PROJECT NO. PR-2021-005411

Application No. SI-2021-00760

**RE: AUTONATION DRB RESPONSE TO COMMENTS
PR-2021-005411**

Per the correspondence via email of Ms. Jeanne Wolfenbarger, P.E., Transportation Development, dated June 22, 2021, please find the following responses addressing the comments listed below:

SETBACKS
FRONT PER PLAN
REAR PER PLAN
SIDE PER PLAN

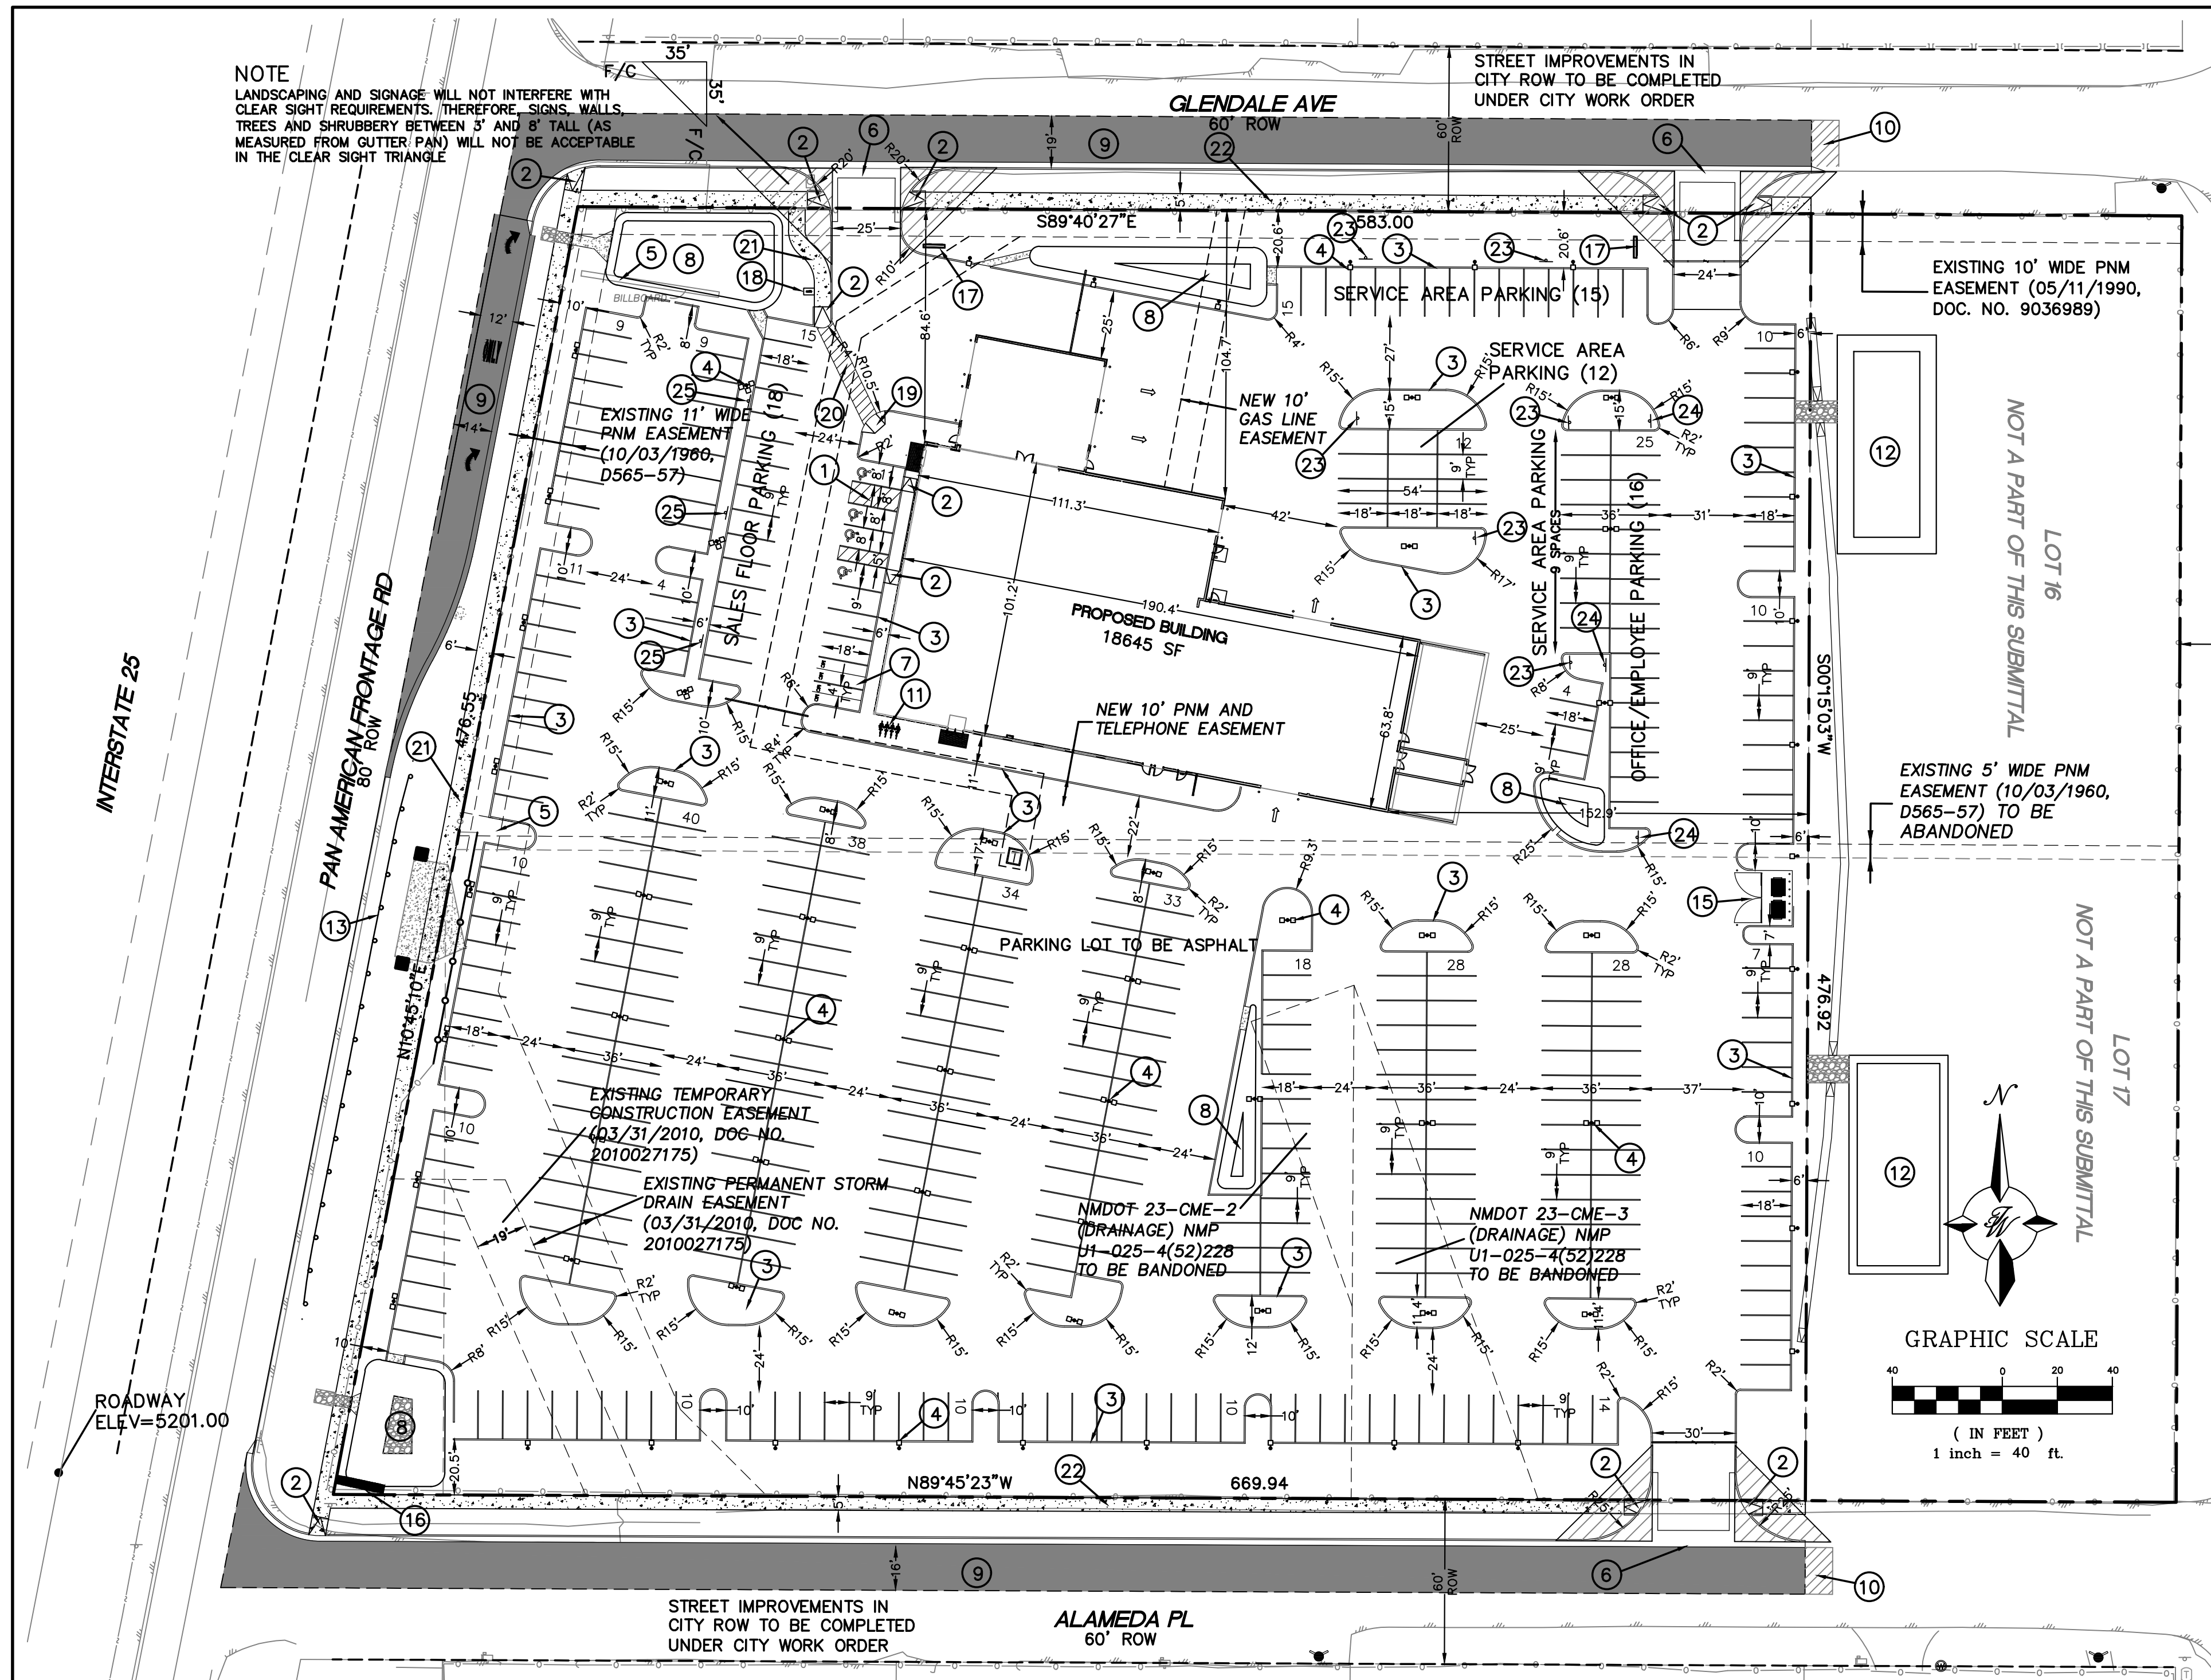
5. Provide bold note for work order being required for all public infrastructure. Eliminate the note about 24-hour required construction for arterial roads on the site plan.
The 24-hour work note was deleted and the other note was added stating a Work Order is required for any work in the City right-of-way.

6. Show overall required parking in the parking calculations versus provided parking. The hatching is difficult to read for storage of vehicles versus customer and employee parking. Use notes on the site plan as well as signage for designated parking.
A column was added to the parking calculation table showing what is required. Also, the hatching was removed and notes added designating the different parking areas on the Site Plan.

7. Label parking aisle width south of the building.
The width is now dimensioned.
8. Label width of all handicapped spaces, and accessible aisles on the site plan.

11. Show clear sight triangles on the landscaping plan, and include the standard note. Clear sight triangle should also be shown on the southern driveway.

15. Turning radii for parking lot islands shall match DPM standards. Provide 15-foot turning radii for all of the landscape islands at the end of the aisles.

17. Call out asphalt paved surface on the site plan for internal parking lot paving.

The dimensions were added to the Site Plan and are also shown on the detail on Sheet DET-1.

Clear Sight Triangles were added to the Landscape Plan and the Alameda entrance on the Site Plan.

All of the turning radii was updated to the 15-foot radius.

A note was added to the Site Plan stating the parking lot will be asphalt.

DRAWING NO:
LS-101

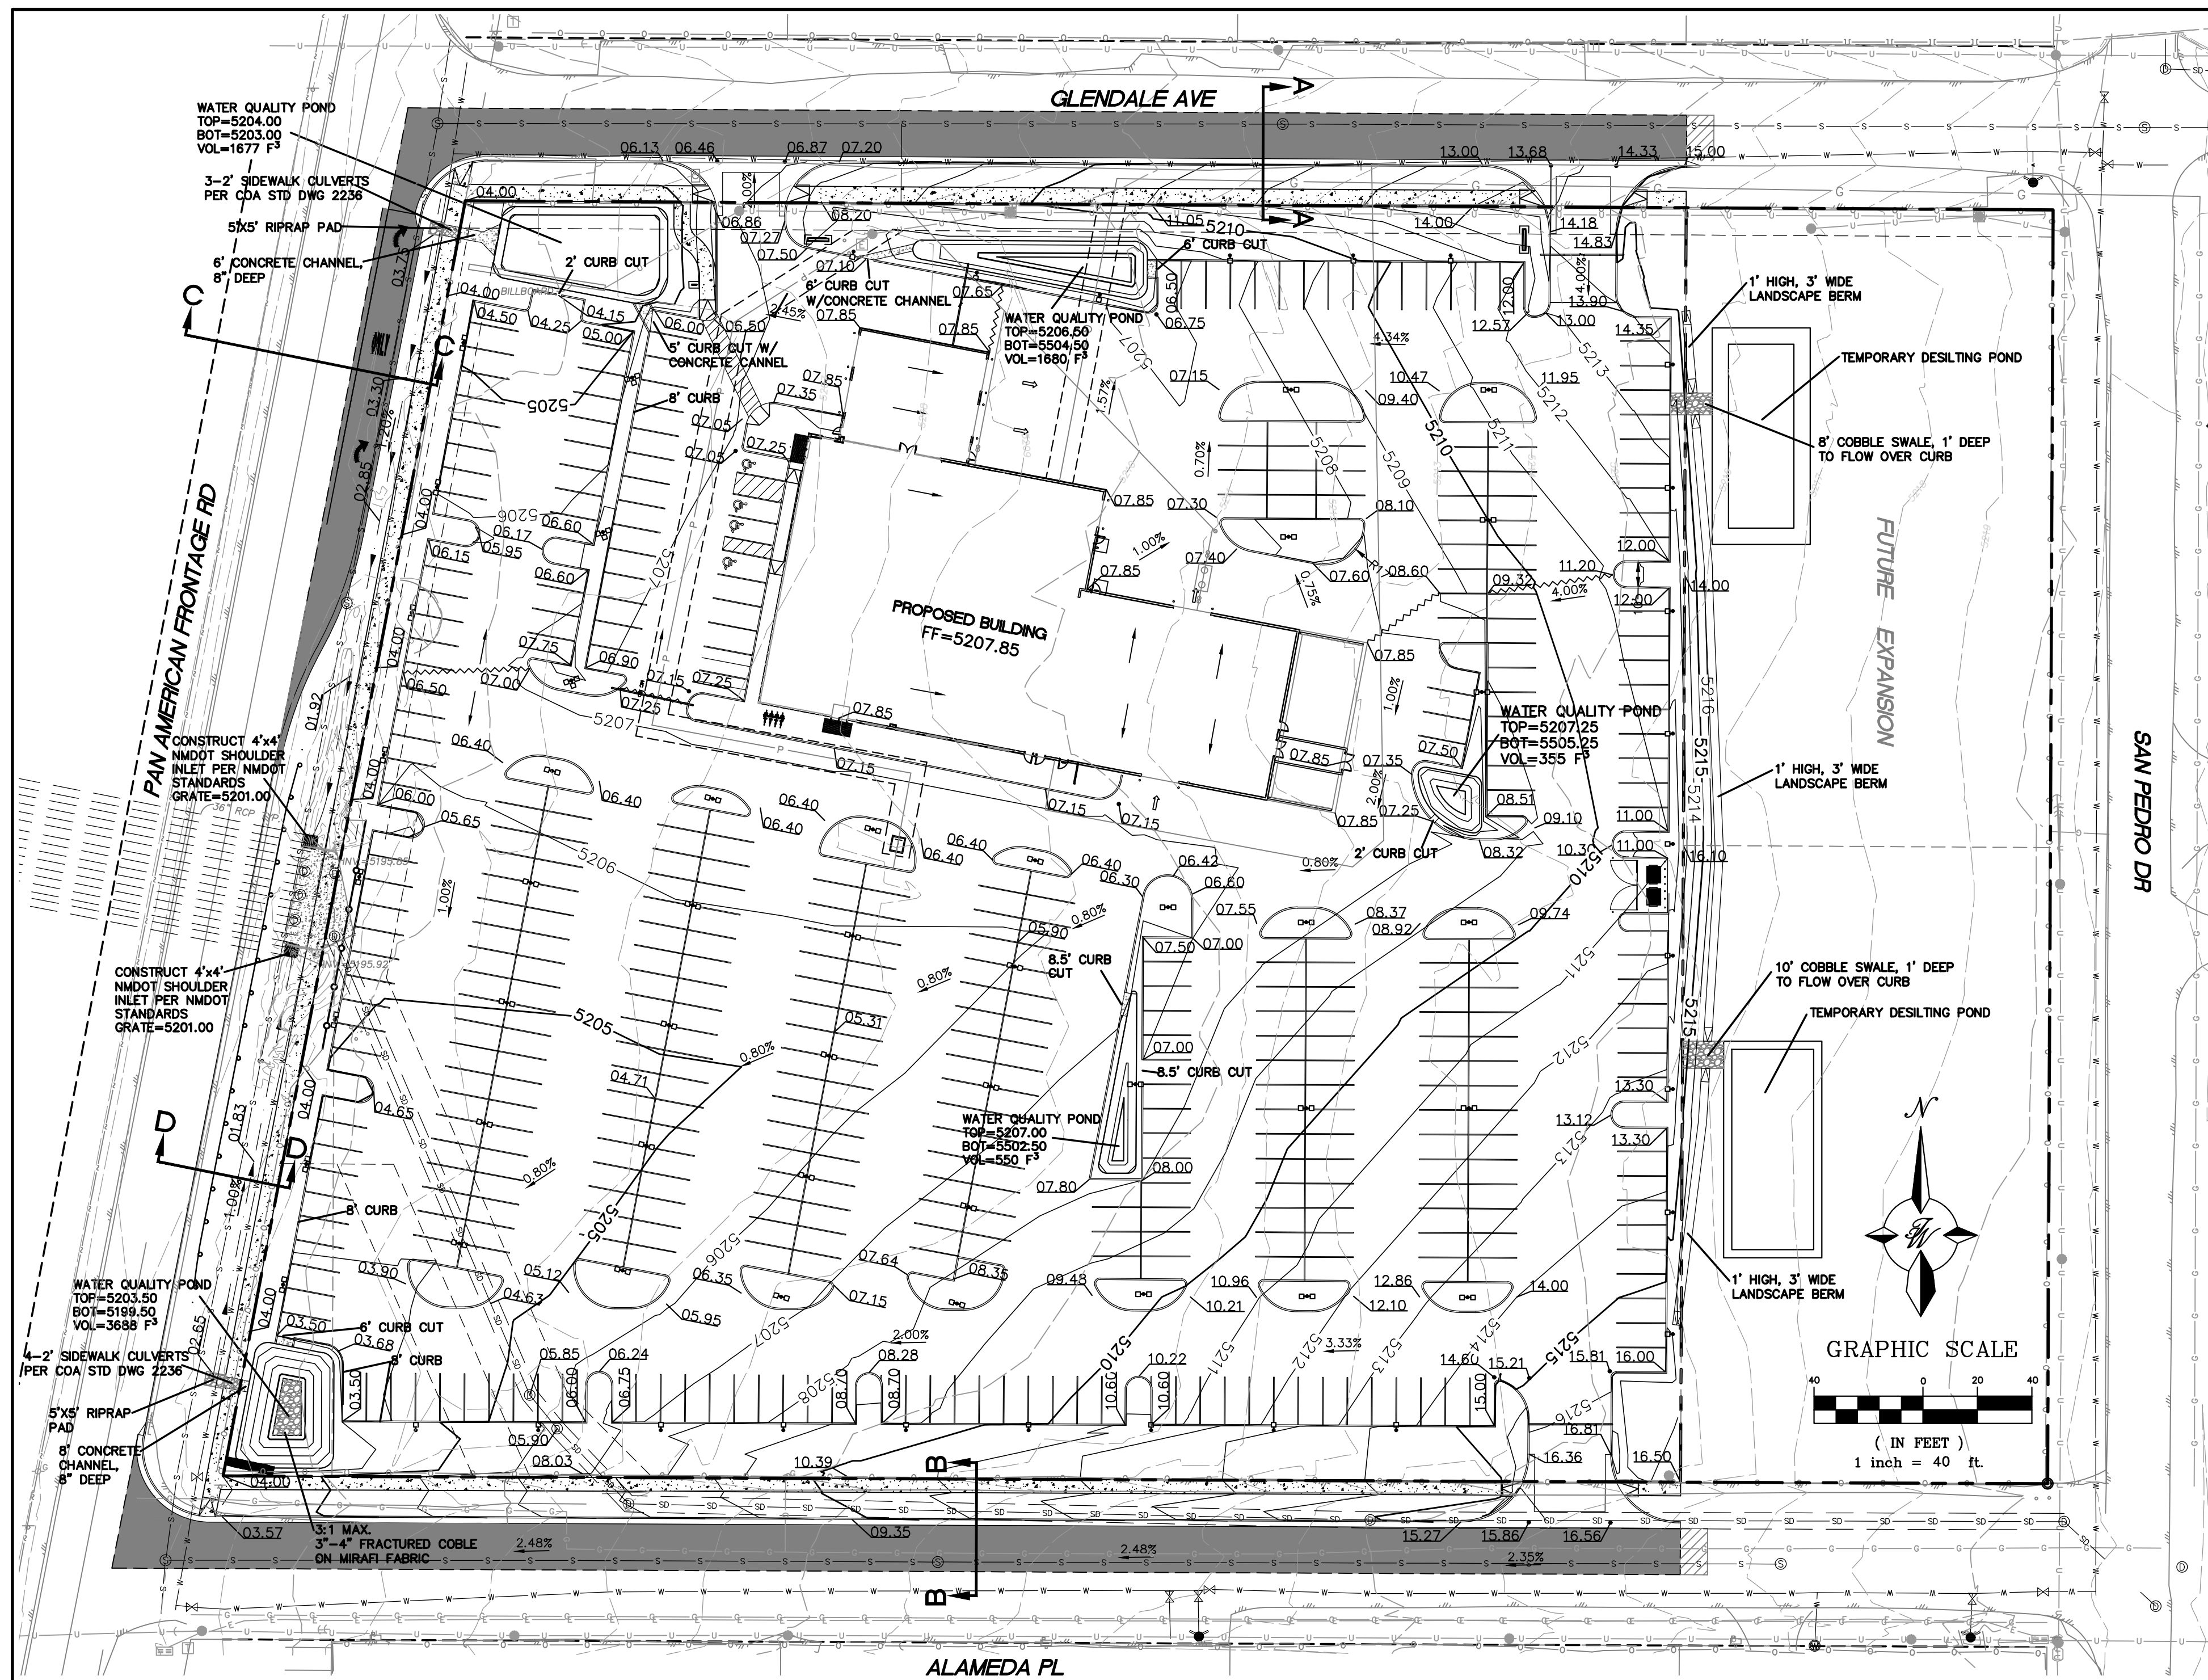
5. Dimension landscape areas so that we can confirm compliance with 5-6(F)(1) Parking Lot Edges and 4-3(D)(19) Light Vehicle Sales and Rental
 - a. 4-3(D)(19)(a) Where allowed, incidental outdoor vehicle display, storage, or

Dimensions were added to the landscaped areas. This project is not adjacent to any residential and thus does not provide for any screening.
